NORTH FALLS OFFSHORE WIND FARM

Appendix B7 to the Natural England Deadline 7 Submission
Natural England's Marine Processes Advice on the Applicant's Deadline 6 Documents

Planning Inspectorate Reference EN010119

15 July 2025

Figure 2-1 - Disposal site

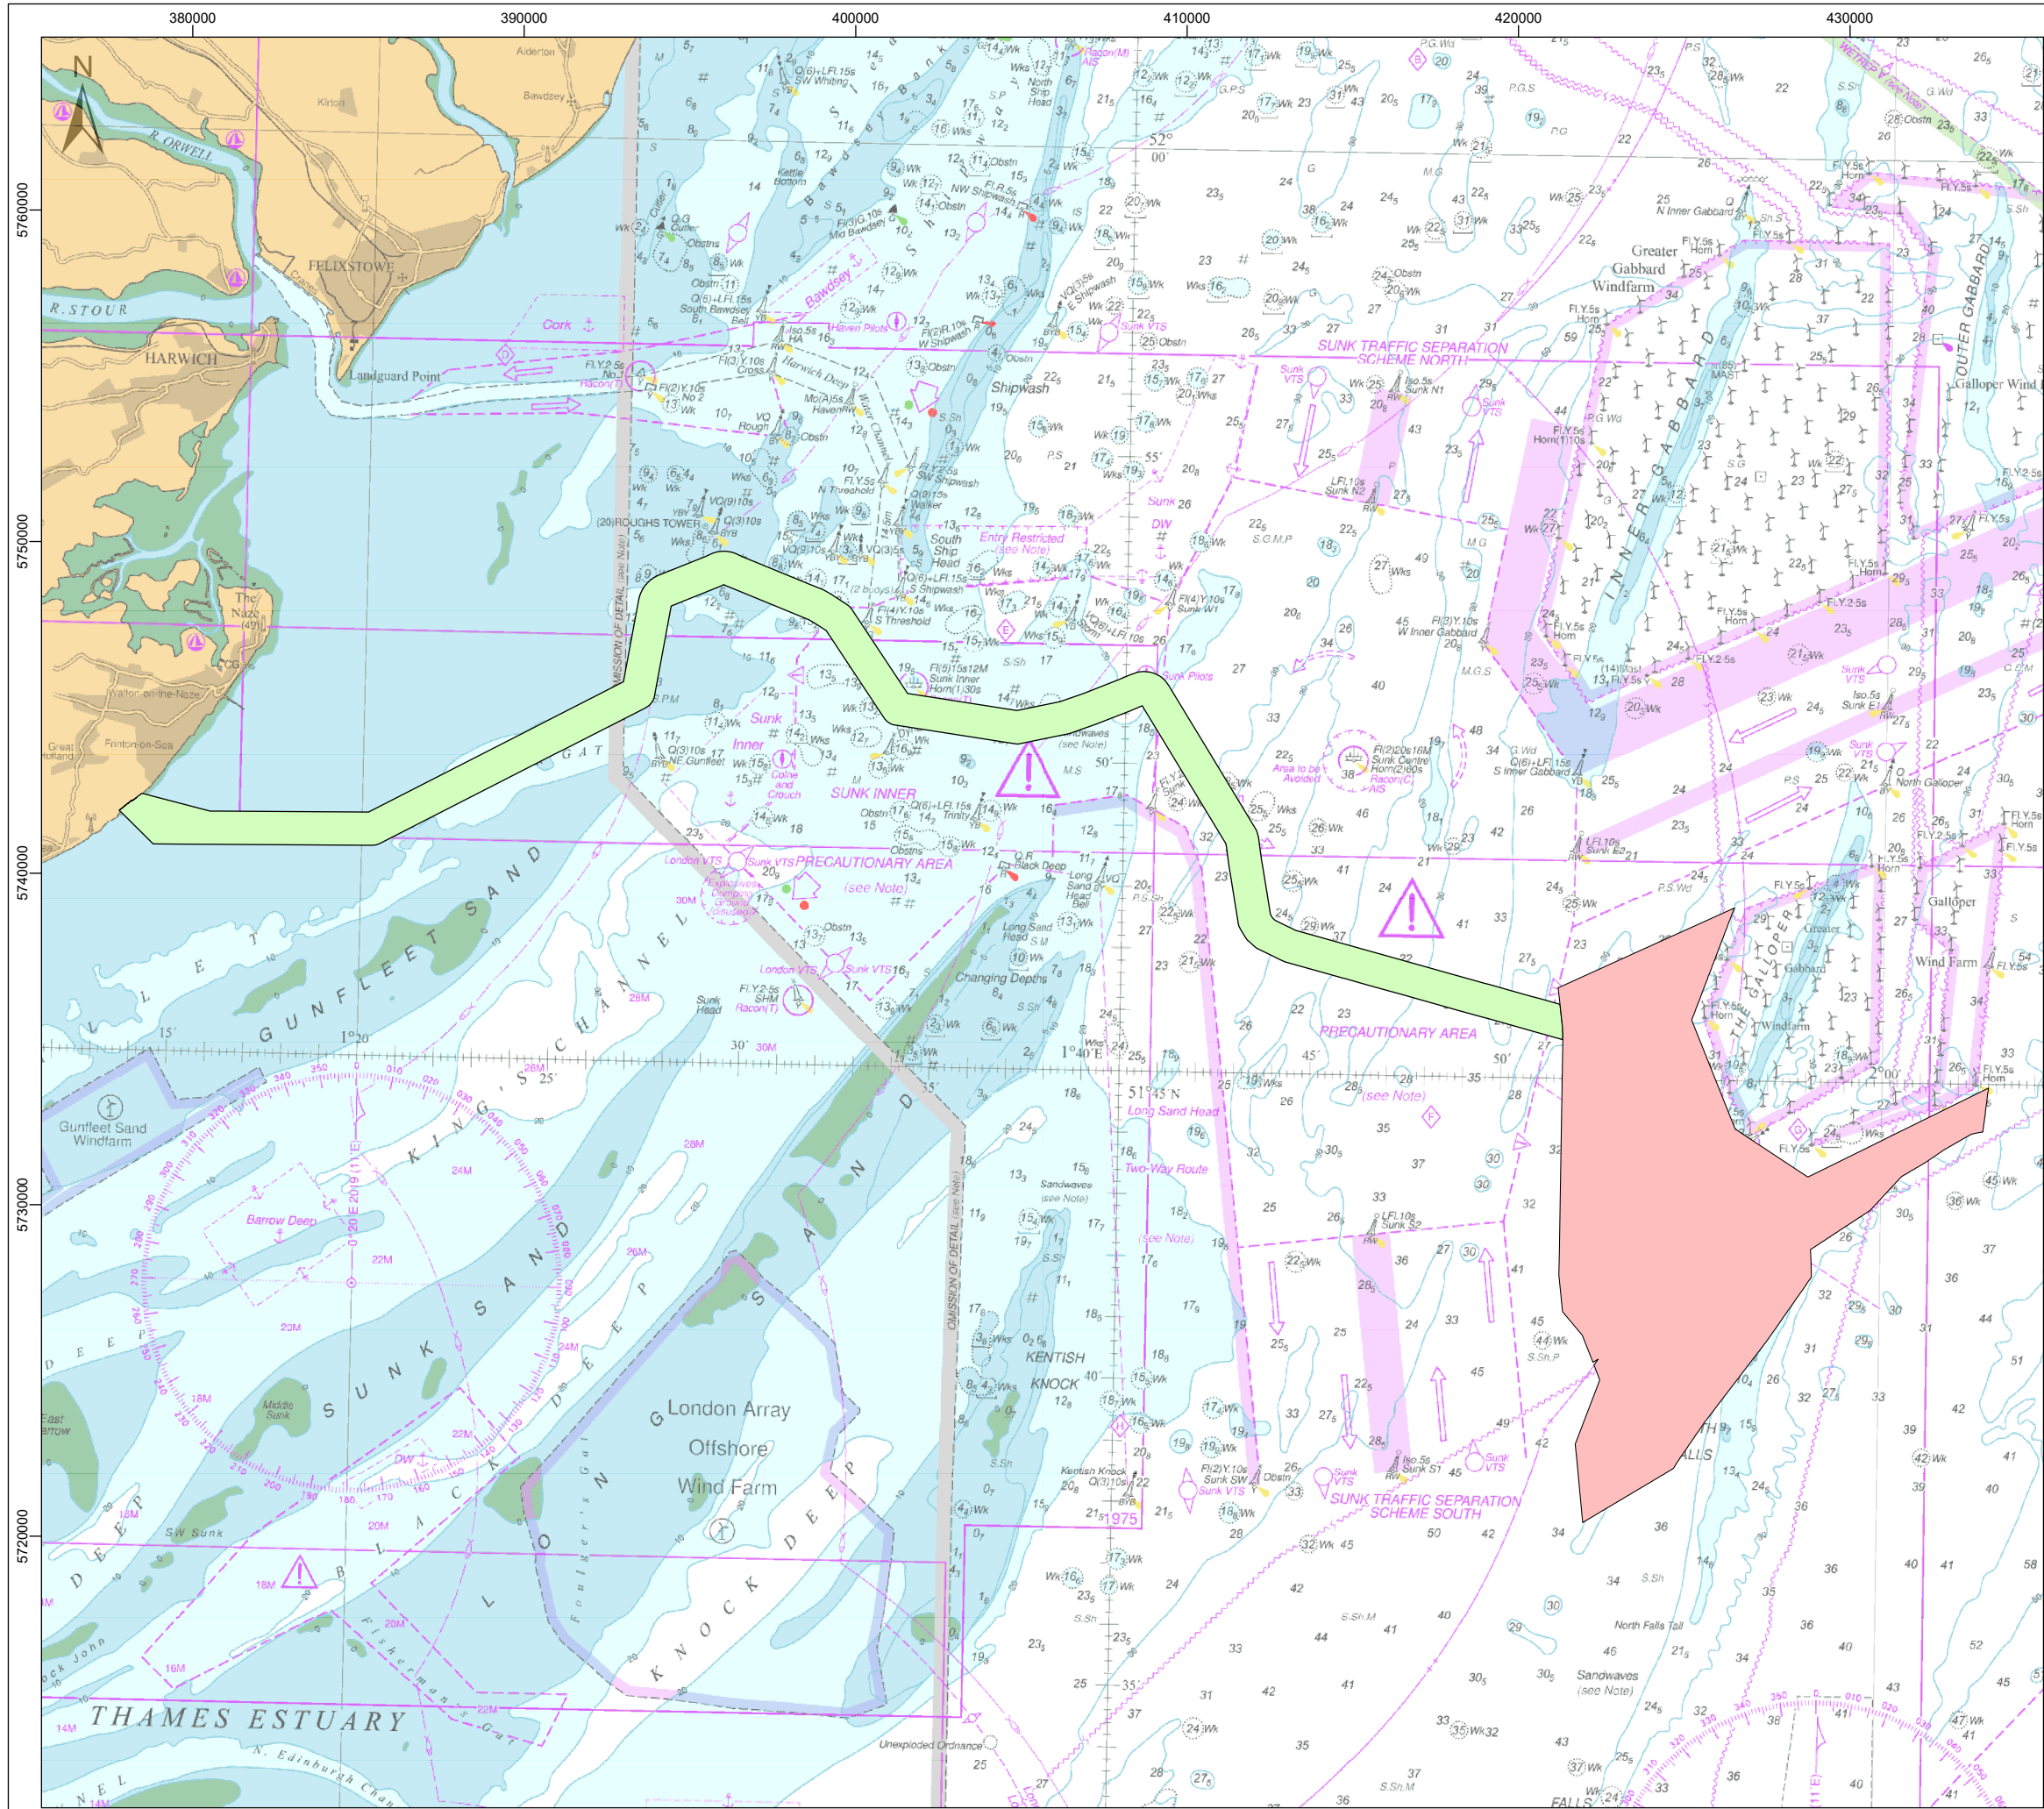
Document reviewed	Update made	Issue Resolved?
[REP6-050]/3.4	<p>Natural England notes that the Applicant's commitment to dispose of any dredged sediment at a distance of greater than 1km from KKE MCZ. This is welcomed. However, the WCS sediment deposition thickness and footprint at/within KKE MCZ remains unclear.</p> <p>In [REP6-059] the Applicant has stated that the potential for concurrent construction activities and overlapping sediment deposition can be clarified in updates to the hydrodynamic and sediment dispersion modelling at Deadline 7. Furthermore, the Applicant has stated that an updated MCZA report will also be provided at Deadline 7. Therefore, we consider this matter progressed but await further clarification on the WCS in the updated documents.</p>	Progressed.
[REP6-052]/4.3	<p>Natural England notes that the Applicant has now committed to not placing cable protection in areas where the seabed is shallower than 5m Chart Datum to ensure that there will be negligible impact on the wave regime and nearshore sediment transport. This is the calculated depth of closure and c. 1.5km offshore. This commitment is welcomed. However, we would advise that in shallow water offshore of the 5m depth contour, cable protection should be avoided and where that is not possible the height/profile of any cable protection should be minimised as much as possible to avoid impacts to sediment transport processes and pathways.</p>	Yes (point B6 in the R&I log)
